Ribble Valley Borough Council
Housing & Development Control

Application no: **3/2019/0038/FUL**

Address: **34 Dilworth Lane Longridge PR3 3ST**

Proposal: **Application to create new driveway entrance**

VISIBILITY SLAM
DRAWING MODZ 'A'
12/04/19

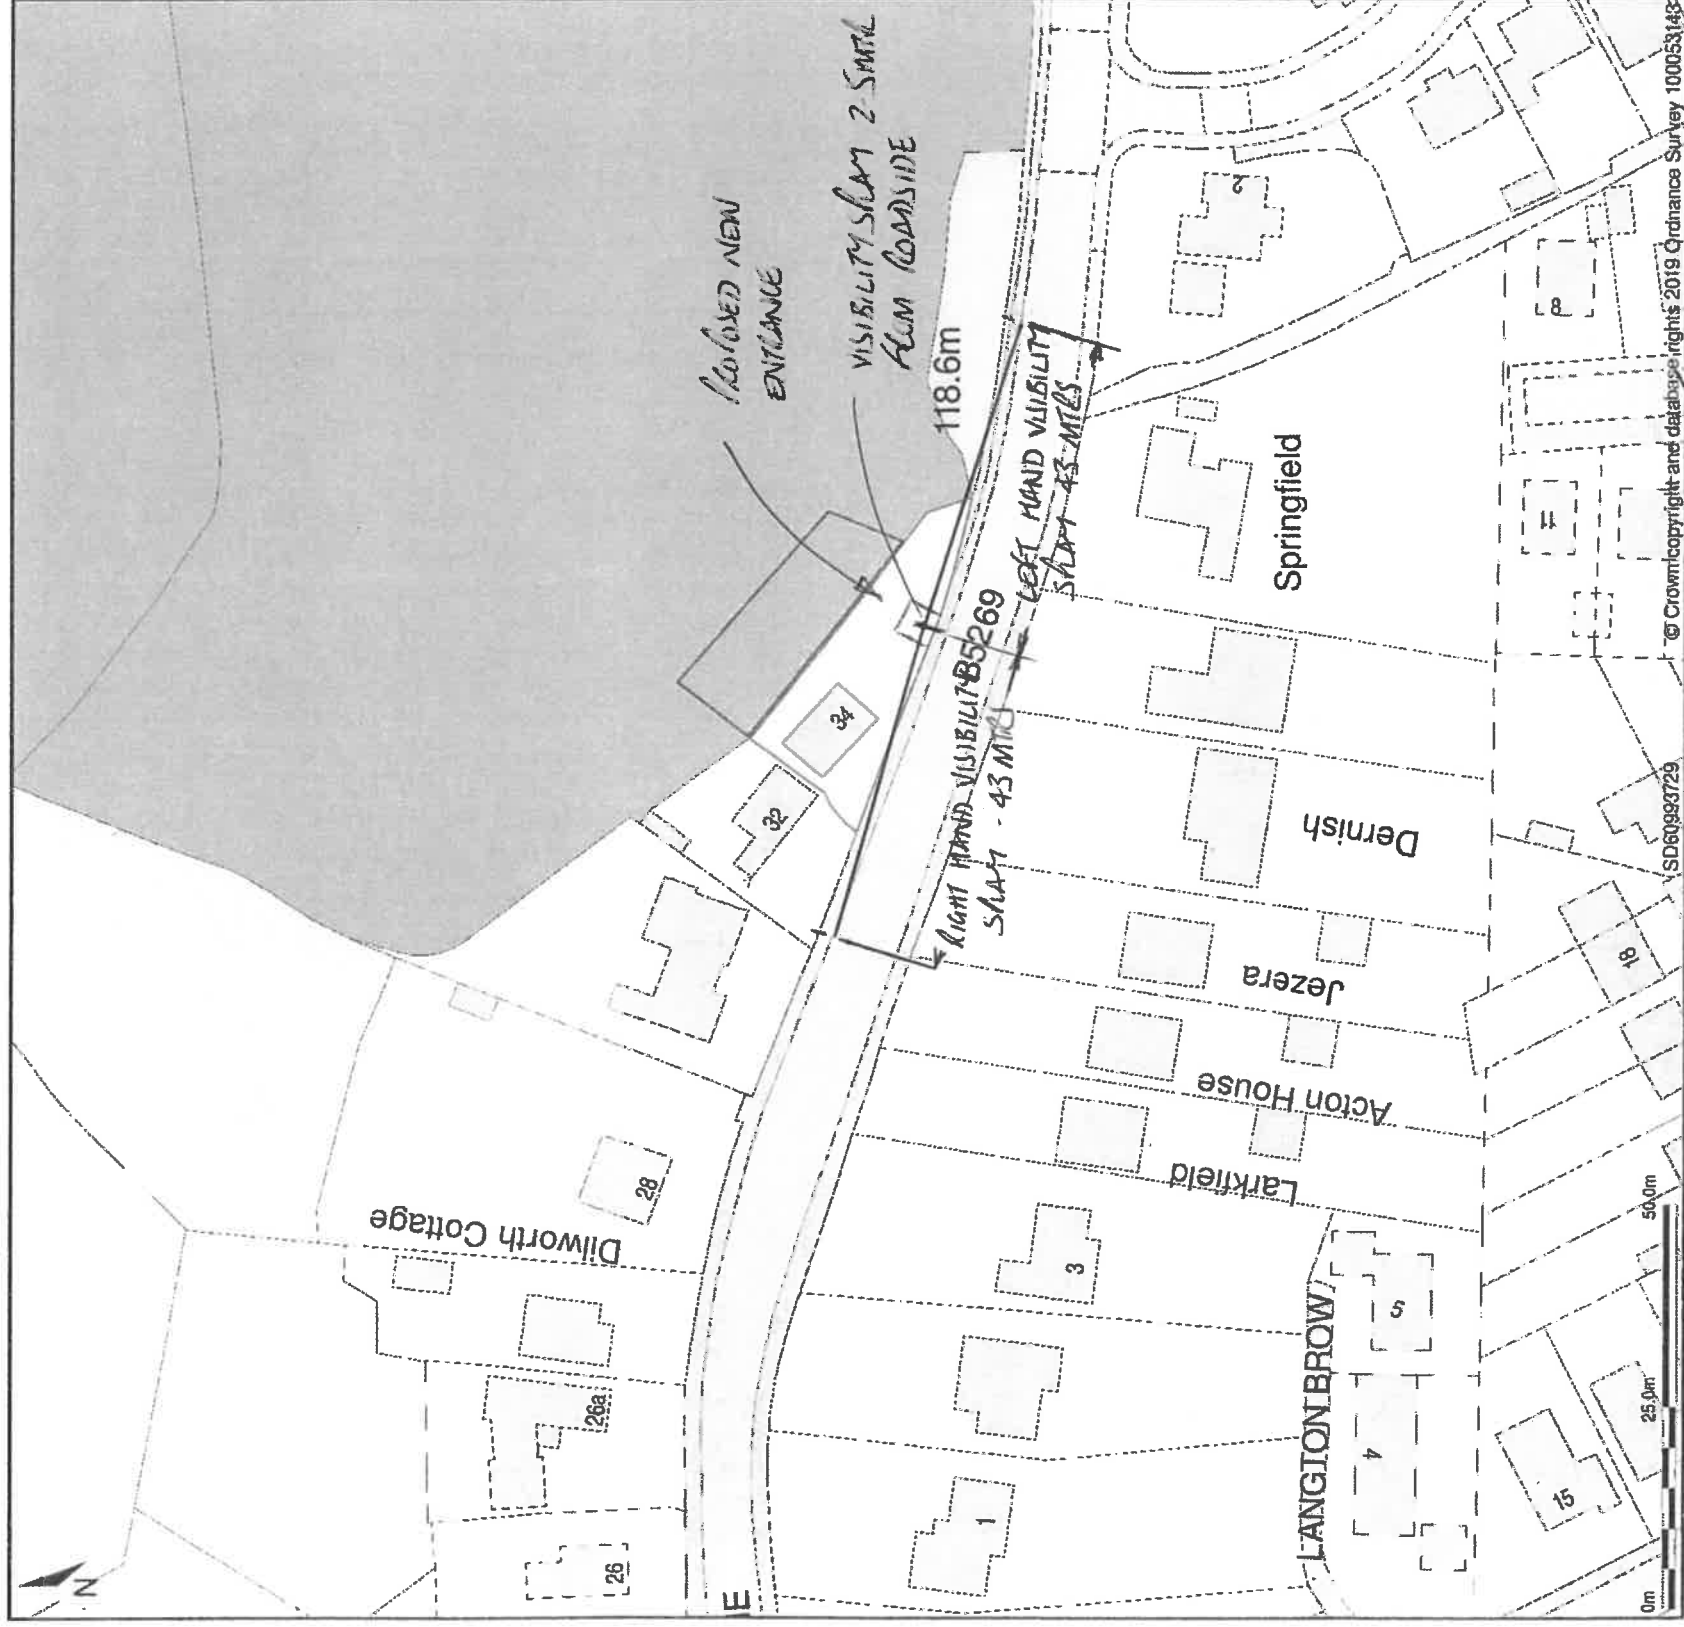
The proposed new access is via a 4m timber gated entrance which is to set back 5m from the rear of the adopted footway adjacent to Dilworth Lane which is adopted highway, namely road number B5269. The revised plans illustrate the positioning of the entrance to be located in a more centralised position in order to aid visibility.

Visibility splays as demonstrated within the revised visibility splay drawing M002 "A" dated 12/04/2019 illustrate visibility splays of 2.5m x 43m. However there is a proposed 1.5m high fence along with a 1.8m high hedge which would obstruct the visibility splays. Therefore the fence and hedge shall be no greater than 1m in height and shall be permanently maintained.

3. Before the development hereby permitted becomes operative, the proposed 1.5m high fence along with the existing 1.8m high hedge on the highway frontage shall be reduced to and be permanently maintained henceforth at a height not greater than 1m above the crown level of the carriageway of Dilworth Lane. **Reason:** To ensure adequate visibility for the drivers of vehicles entering and leaving the site.
